re: **Geotechnical Response to City Comments**
Proposed Residential Building
2458 Cleroux Crescent - Ottawa
to: Melmar Group – Mr. Marc Nakhle – info@melmargroup.ca
date: November 16, 2023
file: PG5973-MEMO.03

DRAWING TITLE: SITE PLAN

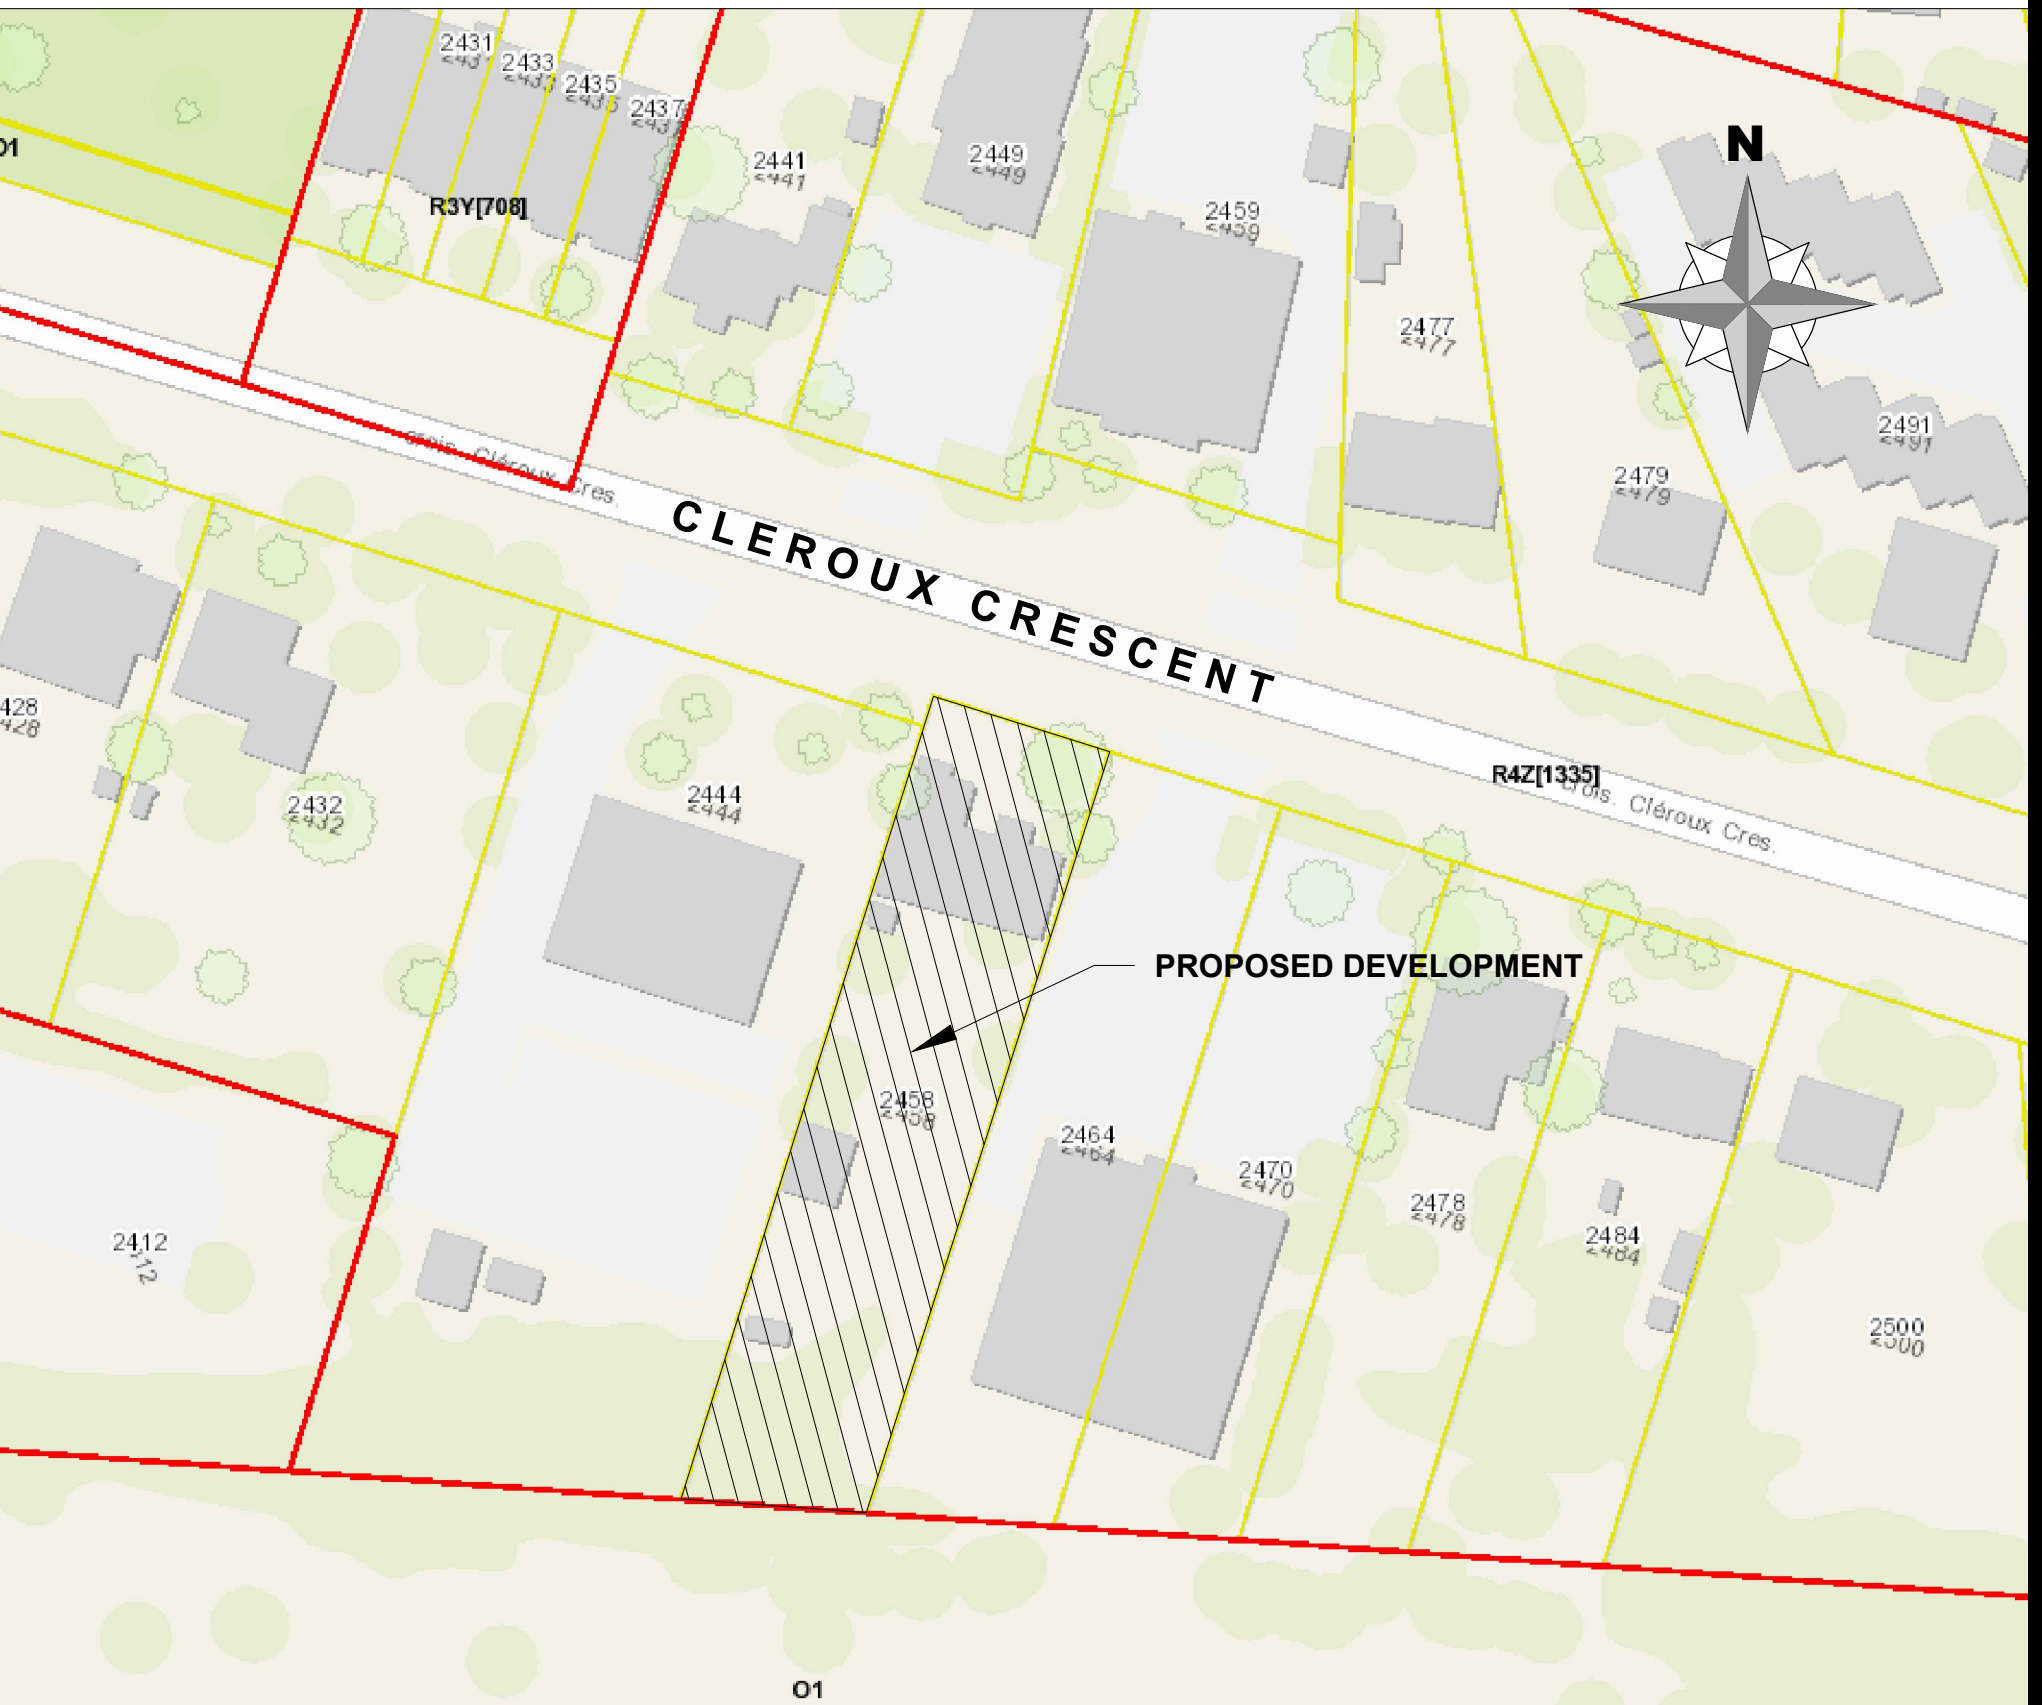
Comment 1: *A copy of the agreement between the owner and adjacent property owner is required prior to Site Plan approval. Is the plan to replace the retaining wall or permanently remove it? Please ensure the temporary/permanent wall removal and ultimate condition on the adjacent property is reflected on all plans.*

Response: It is understood that the existing retaining wall between 2458 and 2464 Cleroux Crescent will be protected from damage that could result from construction of the proposed building. However, an agreement is understood to be in place where the existing retaining wall will be replaced or reinstated by the client as part of the proposed works should the wall be negatively impacted accordingly. It is understood the current architectural and civil design drawings have been prepared on this basis. The agreement letter will be supplied by the client and separate from the current memorandum report. It is further recommended Paterson advise on removal of the subject wall from a geotechnical perspective and associated temporary side slopes at the time of construction and prior to removal should it be required at that time.
